Re: 161 Marginal Way - Maine Eye

Attached is the administrative authorization approval for the canopy, changes to the parking area, relocation of dumpsters with screening, and the equipment area. There are two conditions of approval on the plan and it is the plan with revision date 5/31/16, which is the approved site plan.

2 LEVEL 1 - PROPOSED MECHANICAL/ELEC. LAYOUT  
1/8" = 1'-0"

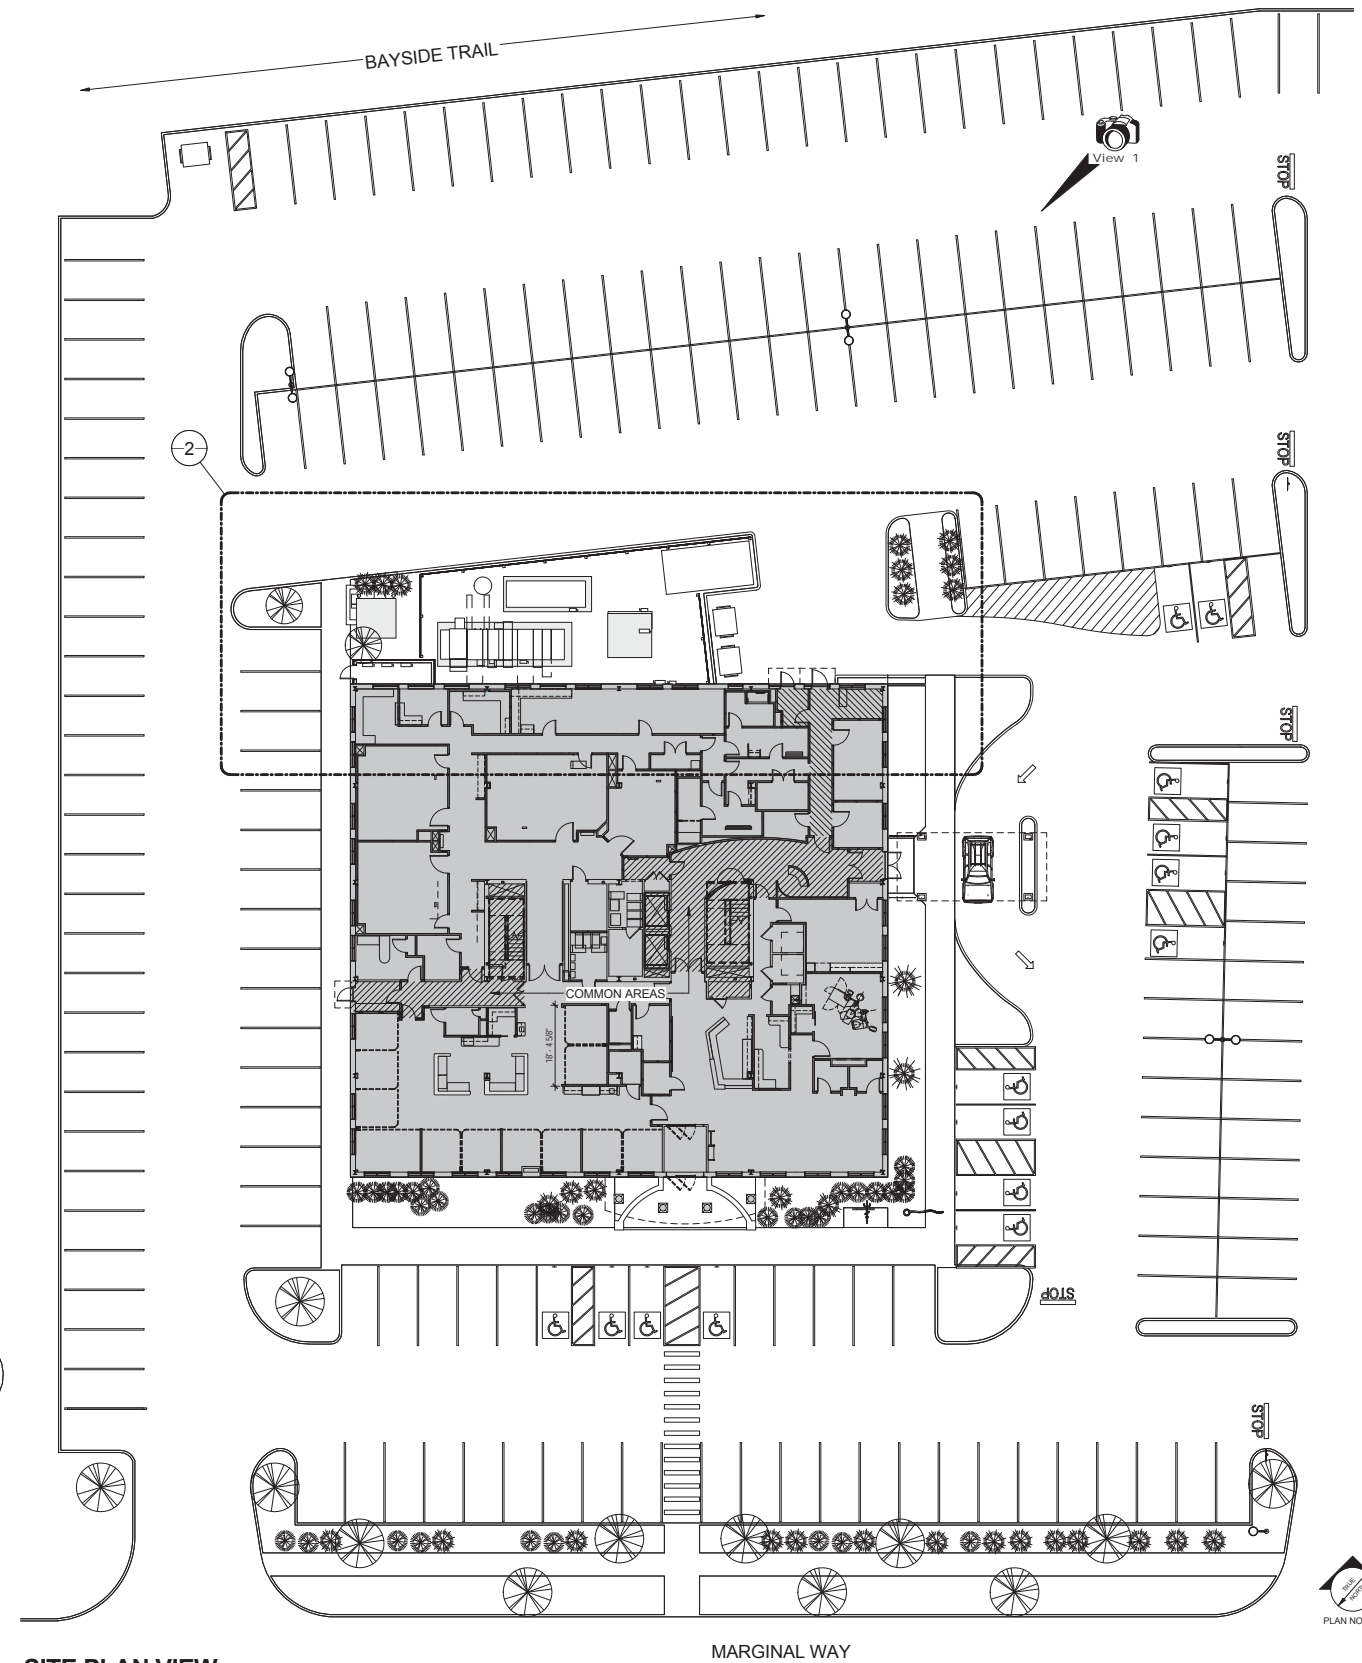
- Is the side entrance for Maine Eye only? Will the front building entrance remain a functional entrance.
- Most of the plans show the dumpster location facing out toward the trail, but the architectural has it tucked behind a shed. What is the alignment and what is being used to screen the dumpsters?
- Is a shed being proposed and what is the size?
- What is the footprint of the equipment in the rear?
- How will the parking function with the drop off area and is this proposed as a one-way circulation?
- We encourage a connection to the trail and is there a detail for the gate? Will the gate be open for use at all times?

**SITE PLAN**  
OF: **MAINE EYE-RETINA AND SURGERY CENTER**  
161 MARGINAL WAY  
PORTLAND, MAINE 04101  
FOR: **MAINE EYE CENTER**  
15 LOWELL STREET  
PORTLAND, ME 04102

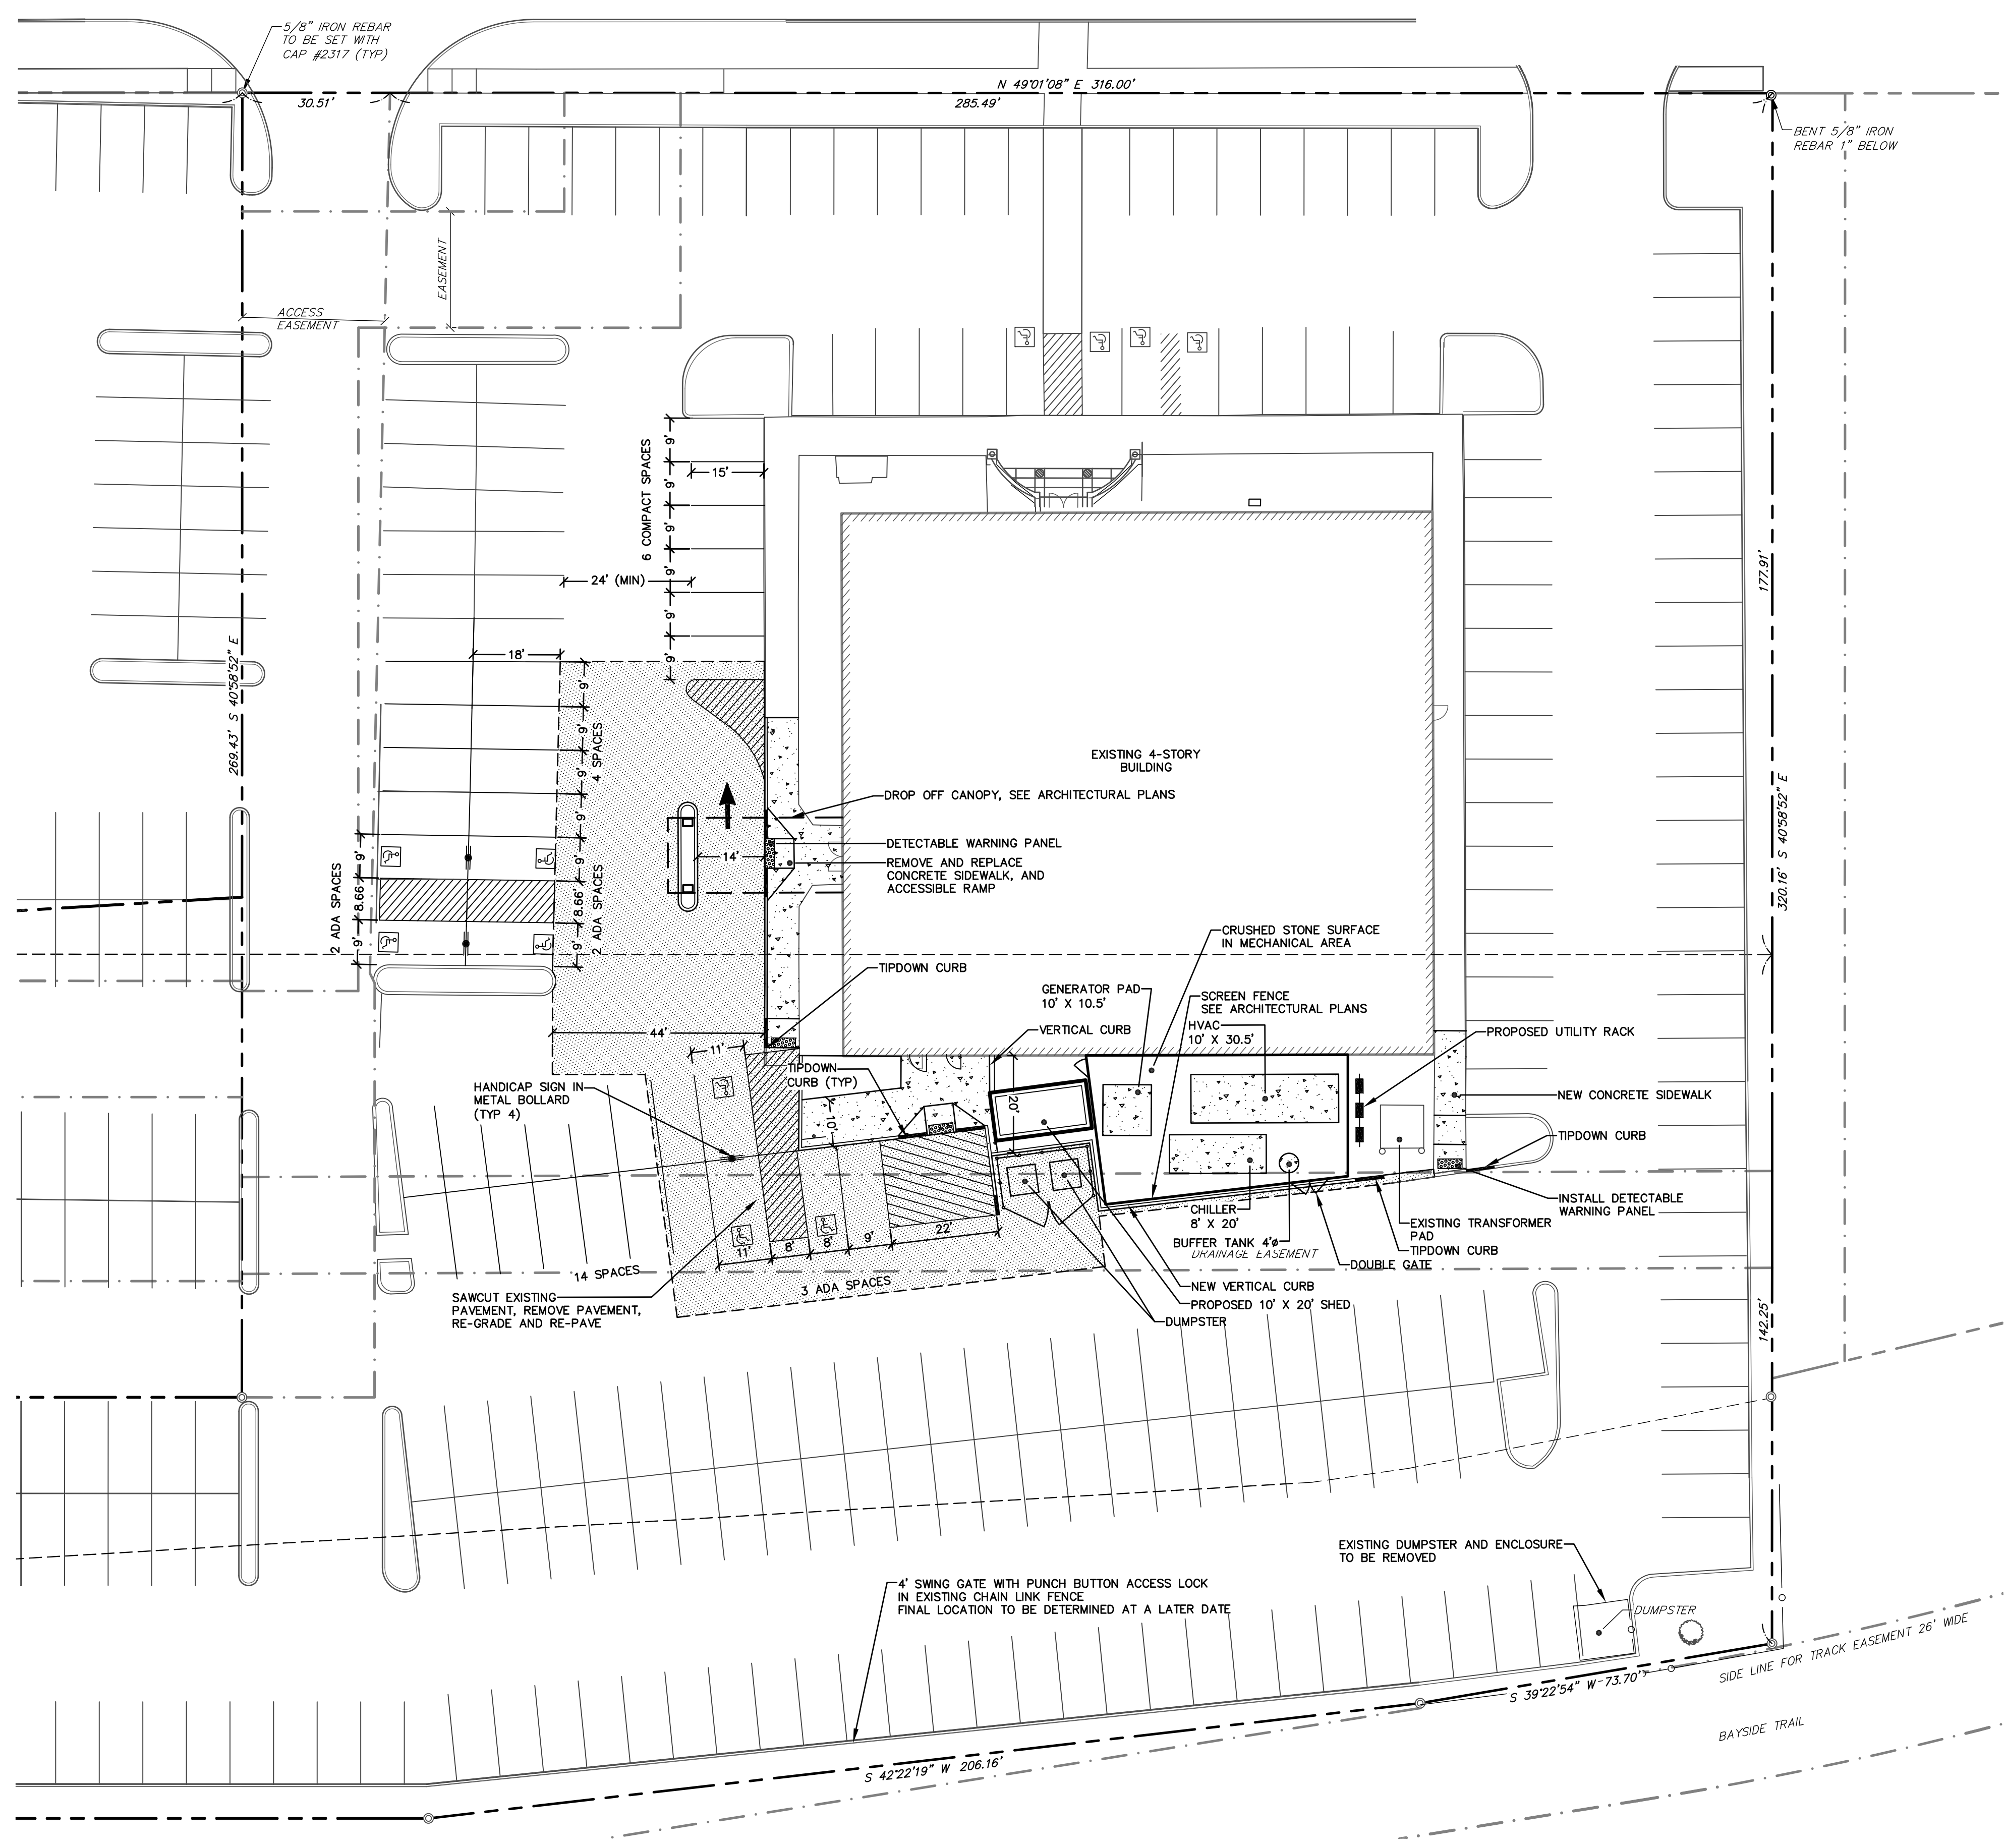
Let me know if the space can return to compact and please send me a revised plan. I will try to talk with Tom today, but I think I will be able to sign off quickly.

The 6 spaces along the side curblineline of the building are depicted as compact spaces which provides for a minimum 24' drive aisle.

Comment response letter attached along with updated site plan and grading plan. The site plan has been updated to add dimensions of the concrete pads as well as a traffic direction arrow at the drop off loop. Grading plan has added note regarding removal of existing dumpster.
